Your Ref: OWPC18049
Our Ref: P/25/18/PL 06-03-2018
Please ask for:
Andrew Wood

Demolition of existing garage, roof alterations to existing dwelling to provide first floor &
1 No. new dwelling in garden of existing dwelling.

Jenin Nyetimber Lane Pagham

Planning Application P/25/18/PL

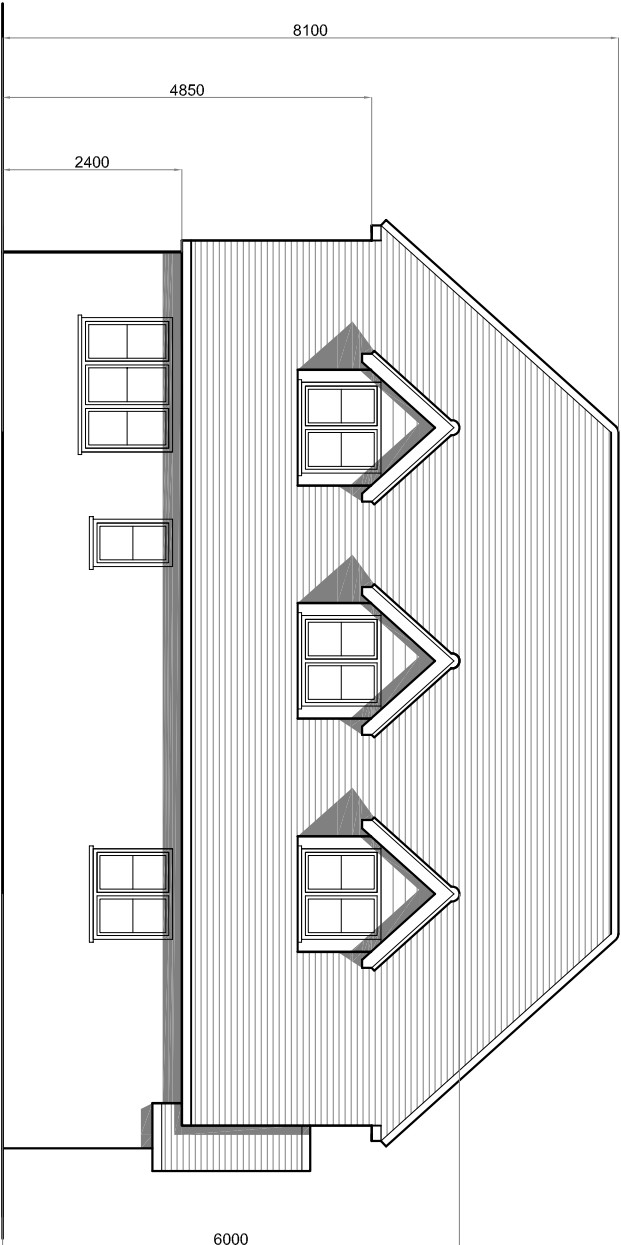
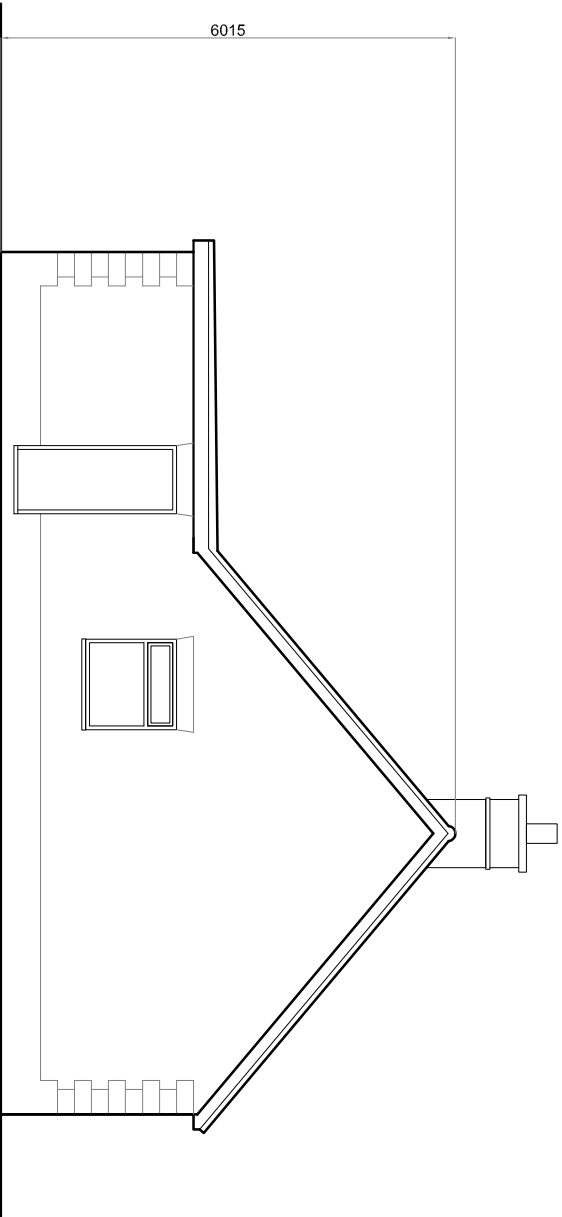
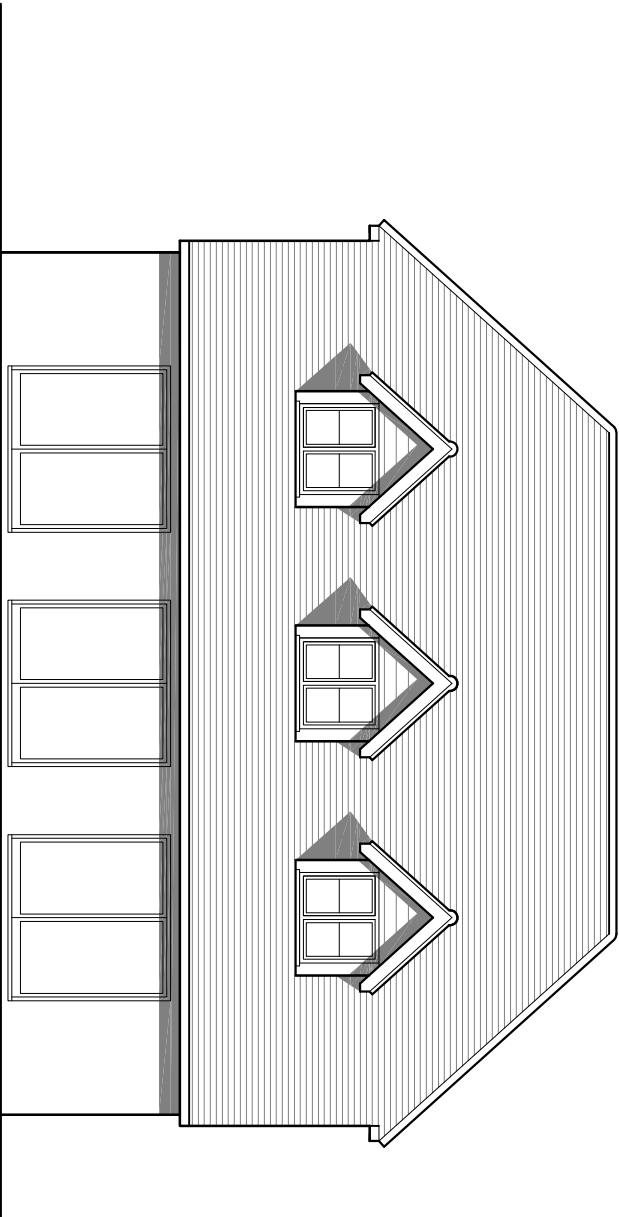
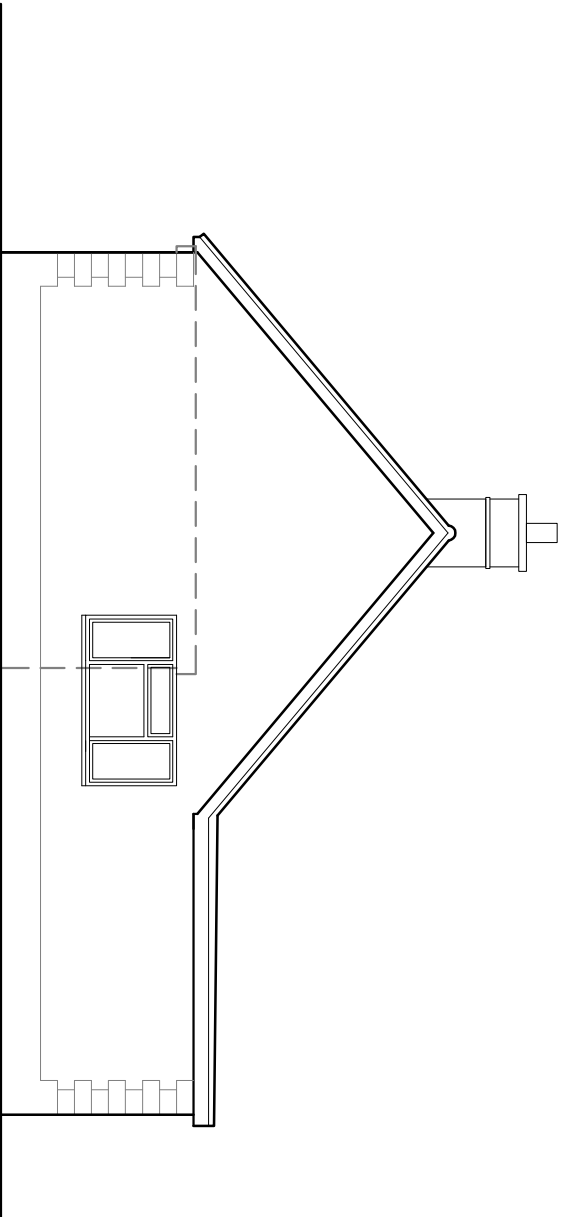
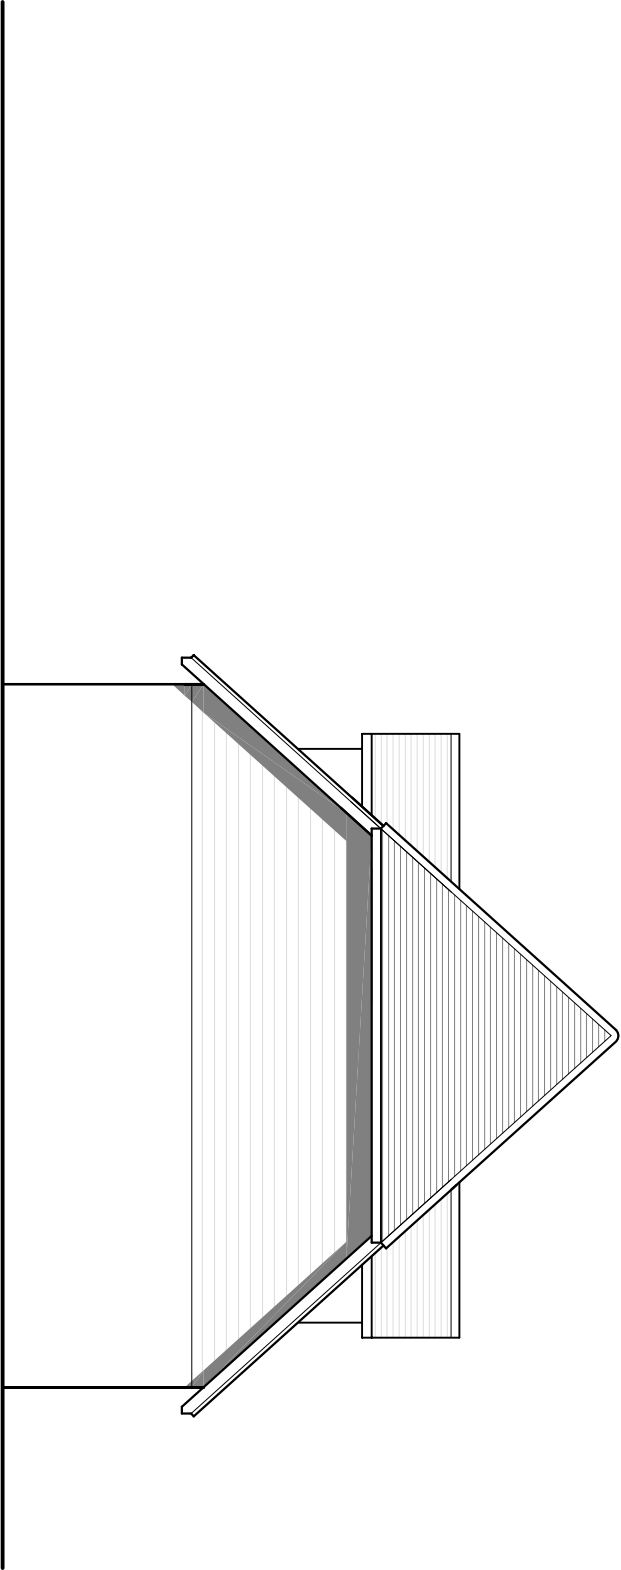
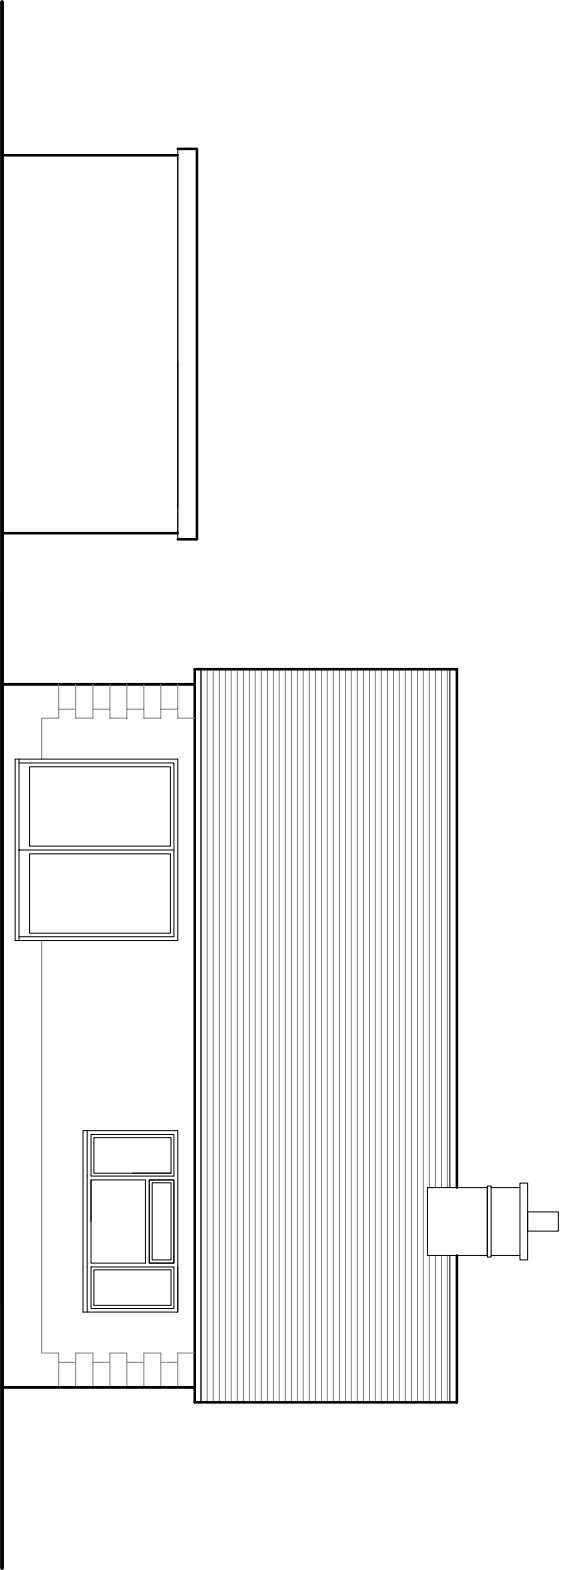
Namely, the design and layout is of poor quality, it has not been supported by a site analysis, it is not consistent with adjacent development in relation to plot size and is overbearing in height and size.

The proposed 2 storey development would completely interfere with the current privacy of properties to the front and rear as overlooking them.

Job Title		Jenin, Nye/timber Lane Bognor Regis PO21 3JT			
Drawing Title	Block Plan Proposed				
Client	R B				
Date	12/05/2017				
Drawn	P.J.G				
Scale	1:500 on A3				
Dwg No.	NT/L/BP/02				B

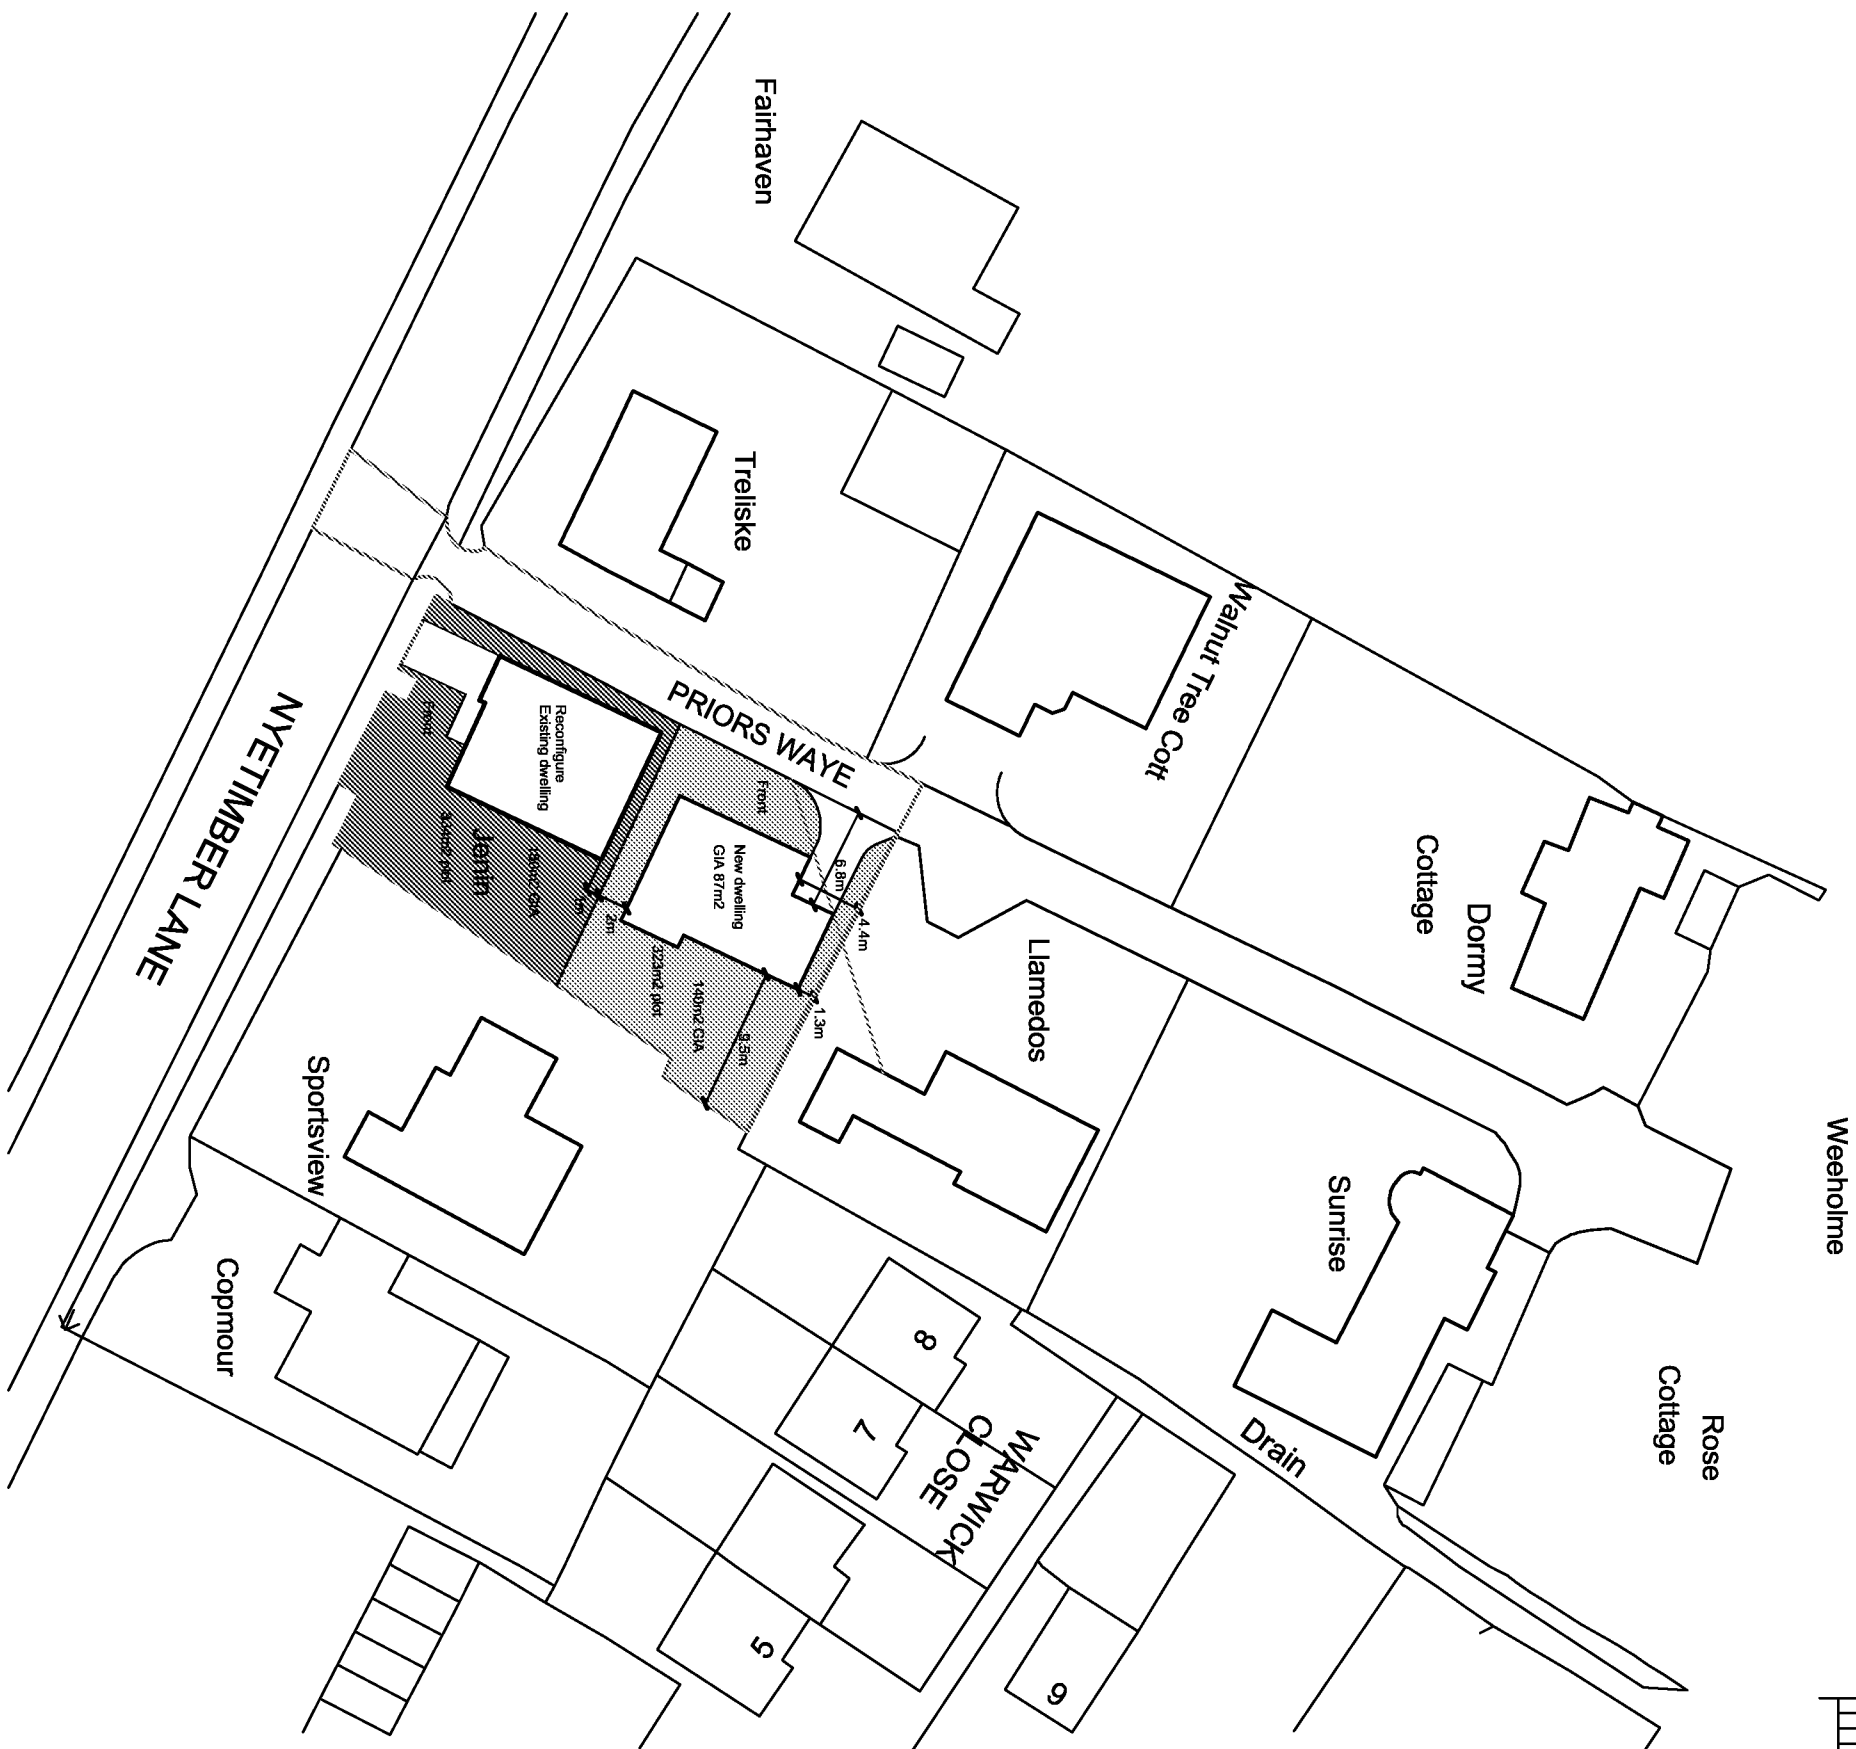
There is currently a significant hedge between Jenin and the adjacent property Llamados which supports a high level of wildlife and has not been shown on the drawing so it is questionable whether the plot is anywhere as big as shown or what the proposals are for this hedge.

Vehicular access to an additional dwelling would be severely restrictive if not impossible due to the existing hedges. A full turning area needs to be provided within the curtilage of the proposed new property.

The current access down Priors Waye is currently 9 ft/ 3 m wide. NOT 12ft wide as indicated in the application.

The proposal does not propose any additional parking to that which currently exists for one property. It only a total of 2 car parking spaces for 2 properties resulting in additional parking in Nyetimber Lane.
